Our Ref: 2007406  
PINS Ref: EN010138  
Enquiries to: Mark Woodger

**RIVENHALL EFW – IWMF EN010138  
ESSEX COUNTY COUNCIL 2007406  
DEADLINE 5 SUBMISSIONS**

The applicant has submitted a further Technical Memorandum, dated 9<sup>th</sup> July 2024 at the Deadline 04 submission reference REP4- 009, and ECC provide further comments to each aspect in turn:

Figure 8.3: Predicted Night-time Specific Sound Level at Grid Height of 4.0m – dB(A)

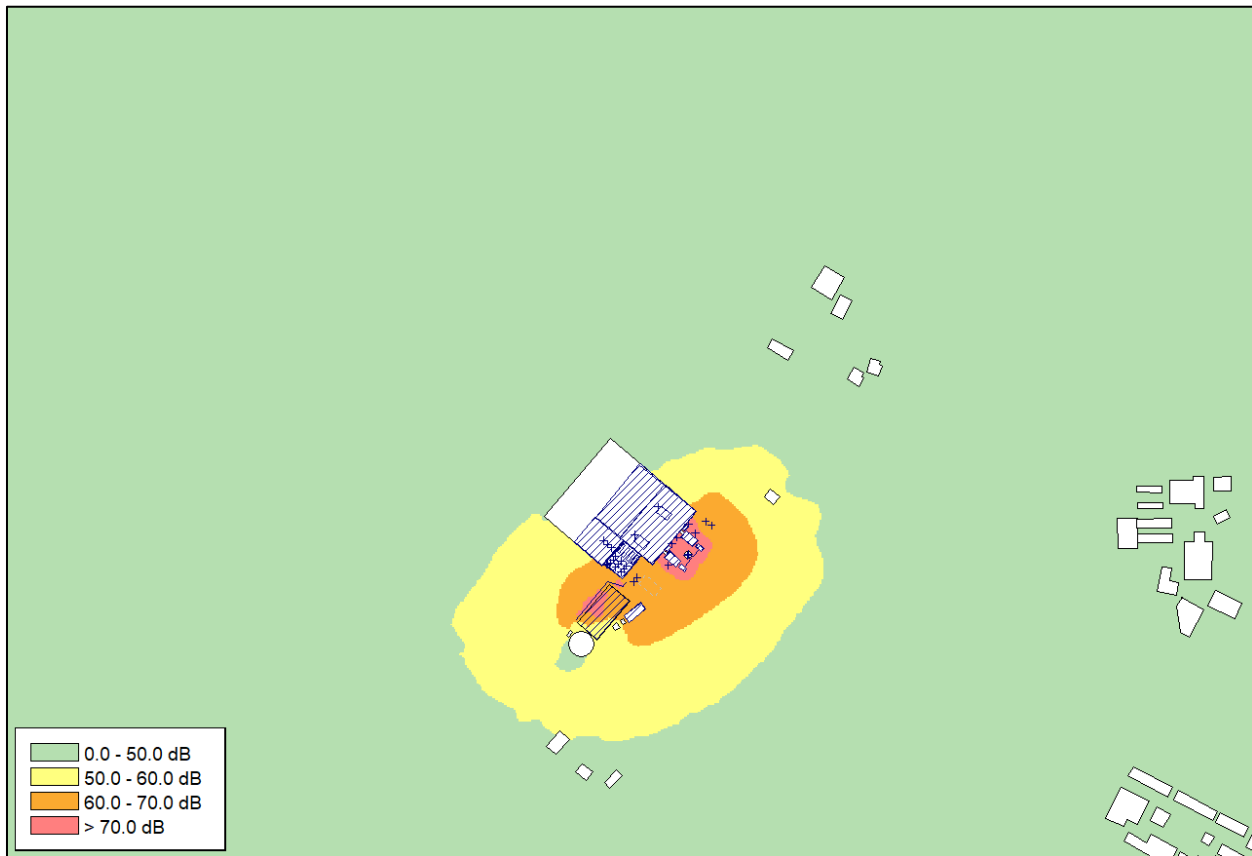
The Technical Memorandum dated 9<sup>th</sup> July (reference REP4- 009) presents predicted night-time noise levels at nearby receptors resulting from the Dry Silo Mortar (DSM) and bagging plant operating at their consented noise limits. These are then combined with the predicted noise levels from the IWWMF and compared to the currently consented noise limits.

- Table 2 of the Technical Memorandum presents combined noise level of the DSM, bagging plant and IWMMF. These are then compared to the currently consented noise limits (note ECC's previous comments with regard to the suitability of the noise level limits). The outcome is as follows:

- The total noise level exceeds the consented noise level limit at Heron's Farm (by 5 dB), The Lodge (by 1 dB), Goslings Farm (by 3 dB), Goslings Cottage (by 3 dB), and Goslings Barn (by 2 dB).

- Of these receptors, with the exception of The Lodge, it is noted that the contribution from the IWMMF is nominal, (i.e. less than 0.5 dB). In addition, for these receptors the noise level predictions specifically from the IWMMF are over 10 dB below the consented noise level limits.

- For The Lodge, the cumulative predicted noise level is marginally above the consented noise level limit of 40 dB (40.5 dB rounded to 41 dB). However, as noted above, the predicted noise levels emanating from the DSM and bagging plant are considered worst case. Should the noise emission be slightly lower (e.g. 2 dB or more) at either of these facilities, this would result in the consented noise level limit being achieved.

Within the document 'Review of Noise Modelling Files' dated 18<sup>th</sup> June 2024, (reference REP3-015) ECC stated '*A full review of the noise models has not been possible at this time due to the supporting data (which may include manufacturer datasheets, noise measurement data, internal room noise level calculations, etc.) not being made available. As such, it is not possible for Jacobs to confirm the veracity of the predicted noise levels presented in the ES chapter.*'

Essentially, the above advises that HZI have 'reversed engineered' noise levels to theoretically demonstrate compliance with the consented noise level limits at the receptor locations. No further details are provided as to the mechanism for obtaining the source data in line with that ECC requested (see above).

It is noted that HZI possess experience in the development of EfW centres, and therefore, they would be expected to apply this to the generation of noise source information. In addition, the confirmation that the facility would not be able to operate until it can be demonstrated that consented noise limits can be achieved provides some reassurance (withstanding ECC's comments relating to the suitability of the noise level limits). Nevertheless, with the lack of evidence provided relating to the origin and application of the source data, ECC can only take the noise level predictions at face value at this time.

The Technical Memorandum (reference REP4- 009) provides responses to other technical noise modelling points that ECC raised. In principle, ECC are satisfied with these responses, with SLR either providing clarity or indicating that they have undertaken updates to the noise model which they advise results in 'no material change' to the predictions. However, given the criticality of the source data to any noise predictions, we are still not able to verify the noise model outputs.

In considering the above, ECC are content that the additional submitted assessment demonstrates that the contribution of noise emanating from the IWMMF, when considering the cumulative effect with the DSM and bagging plant, would not result in an exceedance of consented noise level limits.
